M54/M6 Link Road

Written Representation

Staffordshire County Council

October 2020

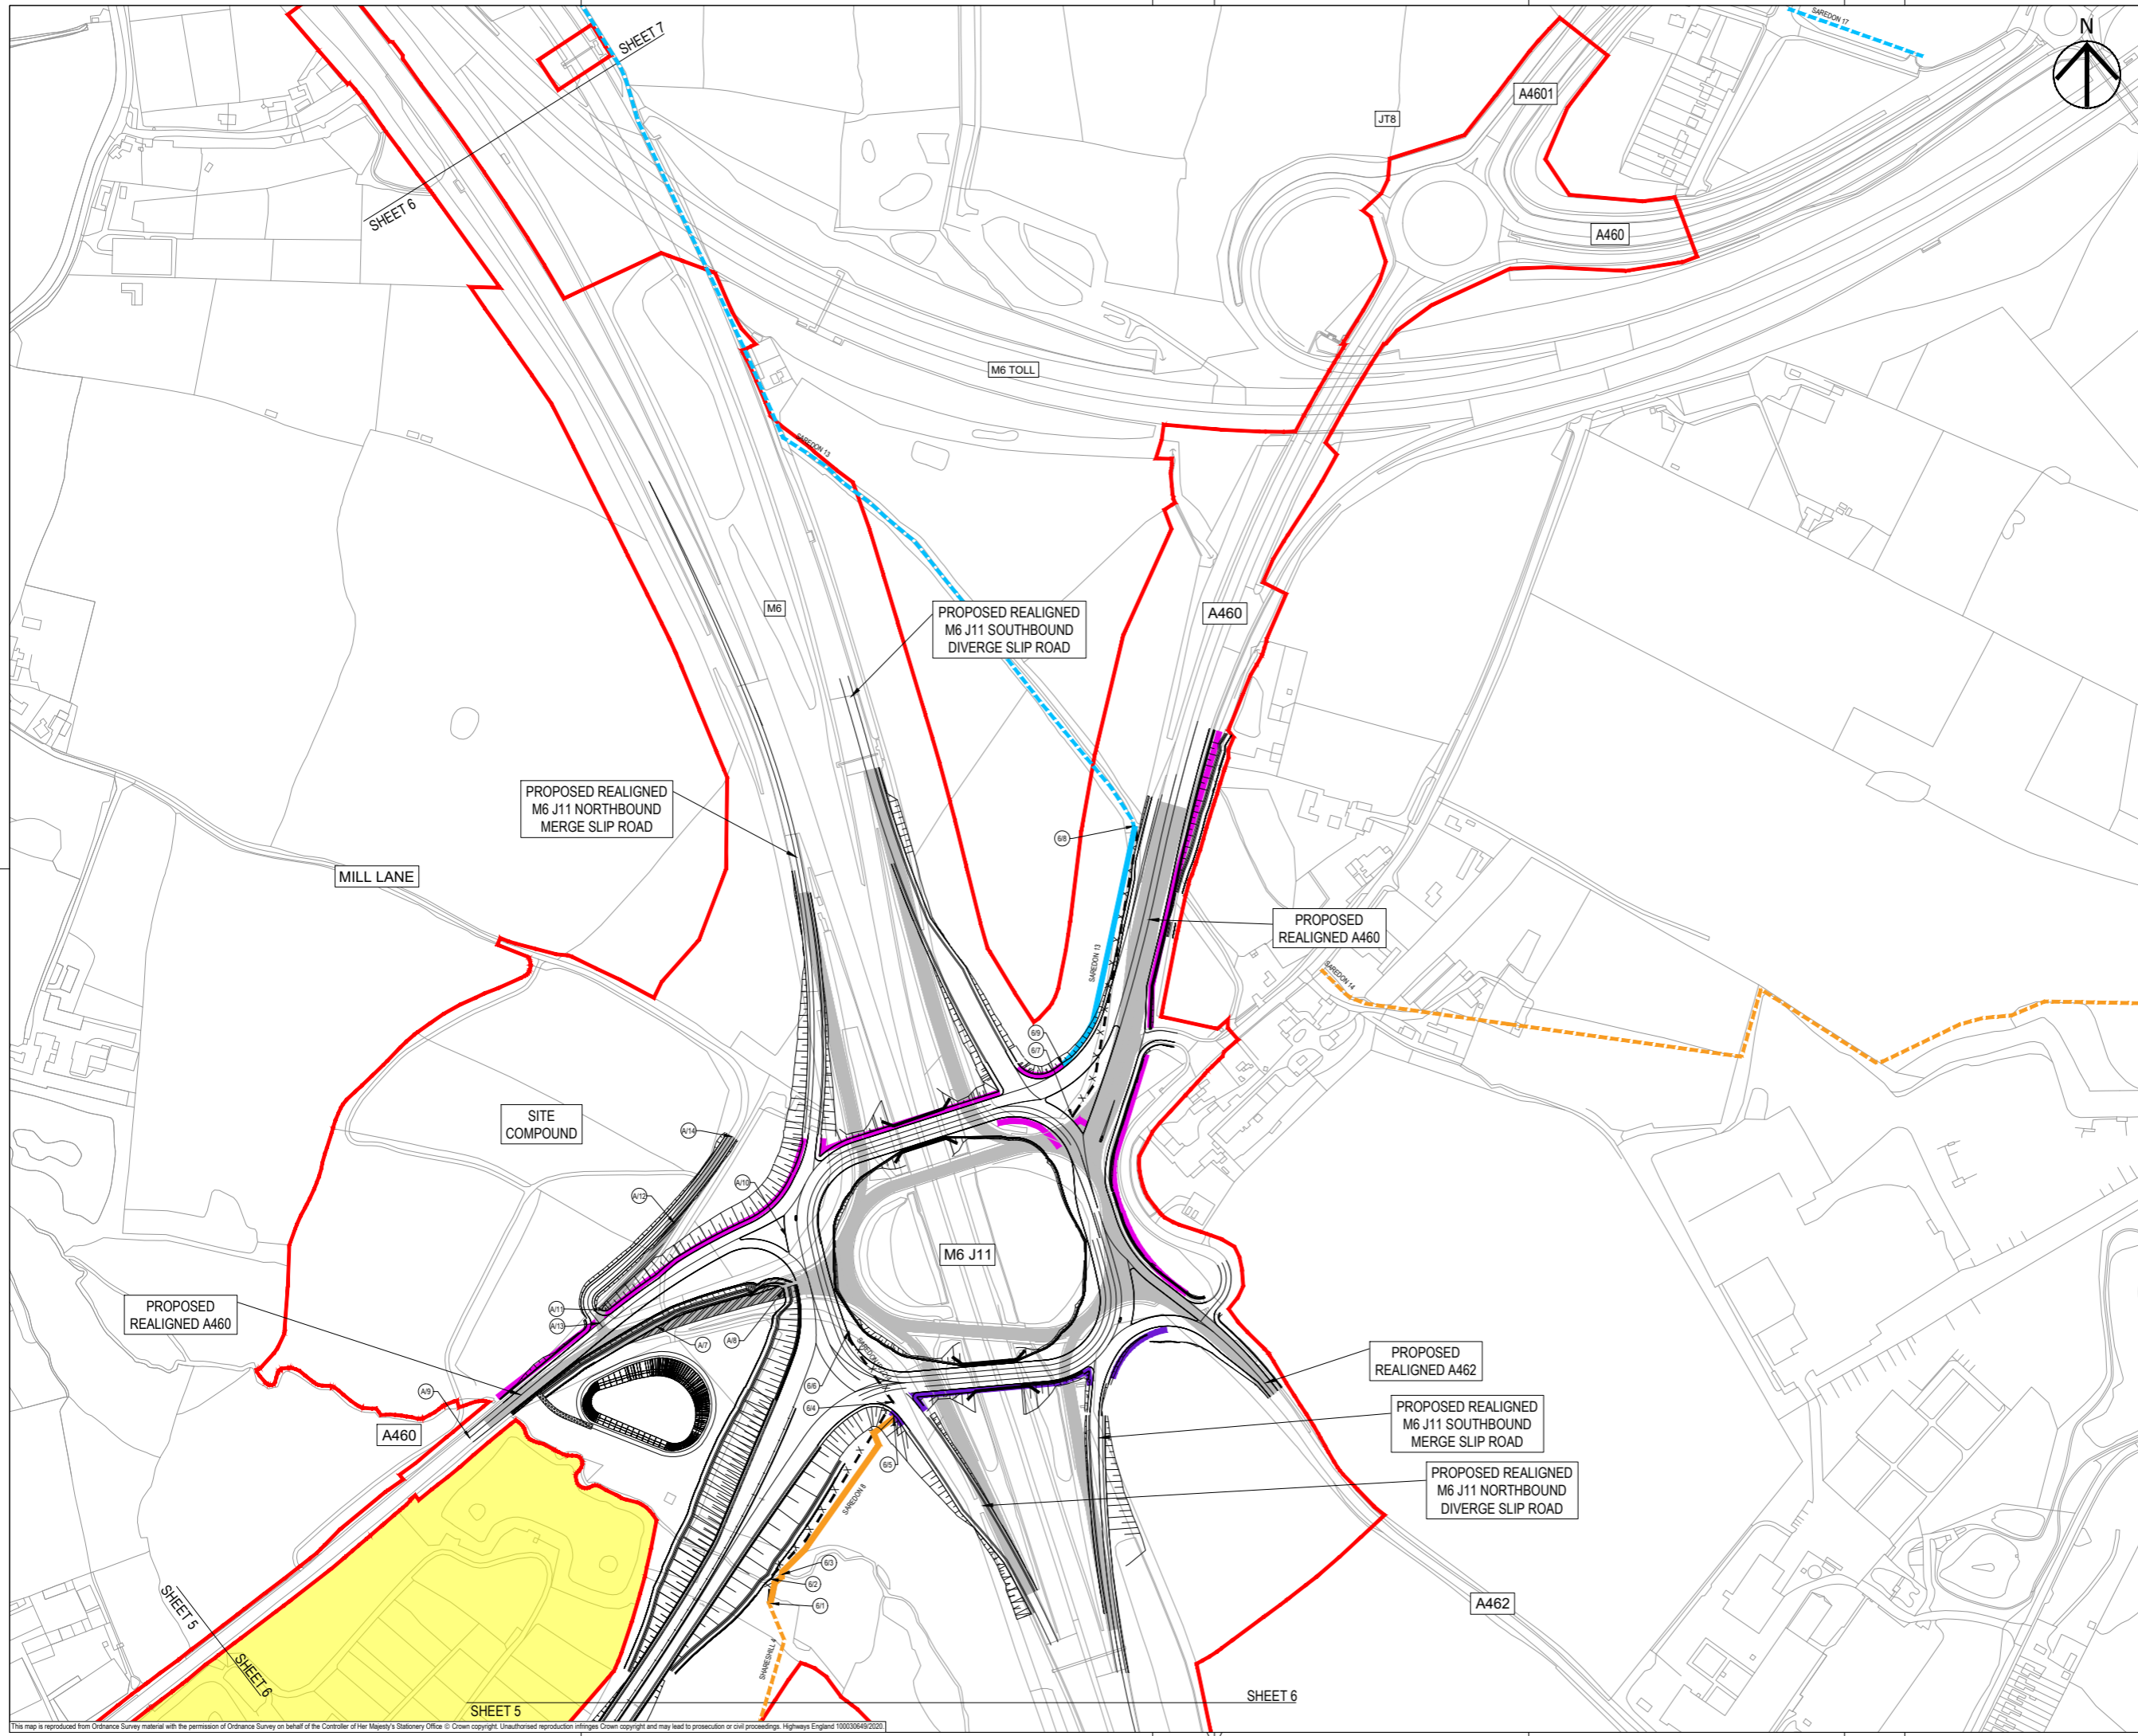
As a result of the realignment of the old A460 there are areas of the original route that are proposed to be stopped up or the carriageway removed as indicated on STREETS, RIGHTS OF WAY AND ACCESS PLANS REGULATION 5(2)(K) SHEET 4 OF 10 . There are two issues here that require further work from HE:

1. Southern section

In relation to the southern section of the original alignment that is proposed to become a cul-de-sac as shown on the extract below. There are concerns that given its proximity to the strategic road network this area may become subject to indiscriminate parking. Further measures are considered to be required here to ensure its use is only for residential access and highways maintenance activities.

2. The area fronting the Petrol filling Station and Public house

The area shaded grey in the extract above identifies the length of the A460's original alignment that HE proposes to remove the carriageway but retain the area as public highway. Our understanding is the rationale for this is down to the presence of utilities in the highway and the cost of diversion. We have several issues with this approach and the uncertainty created. Starting with the access to the public house as annotated above. The pub seems to have two access points to its car park whilst the southern access is broadly unaffected the northern access appears to be made redundant by the proposal but the property would still front publicly adopted highway at this location.

The scheme proposed two new access drives to the Petrol filling station and surrounding uses from the realigned road. The southernmost access drive crosses an area of land shaded white (or unshaded), this land is to be permanently acquired by HE to deliver the scheme. Effectively, as this land is not part of the highway the access drive therefore crosses third party between the new road alignment and the old alignment. Where the access drive sits above the old alignment of the A460 it will be subject to all legislation covering the adopted public highway and would be subject to maintenance at public expense. Similar issues exist for the northern access.

In addition the old A460 alignment as public highway would be usable by the public, which may create confusion for frontage owners.

There is no clarity on what is proposed for the area between the new highway and old alignment or who will be responsible for it. Further on the ground it will be difficult to define areas that are public highway from areas that are in other ownership. We believe the old alignment of the A460 shaded grey in the extract should be formally stopped up and consideration given to how the land between the rear of the new highway alignment and private properties should be treated including access rights and ownership responsibilities.
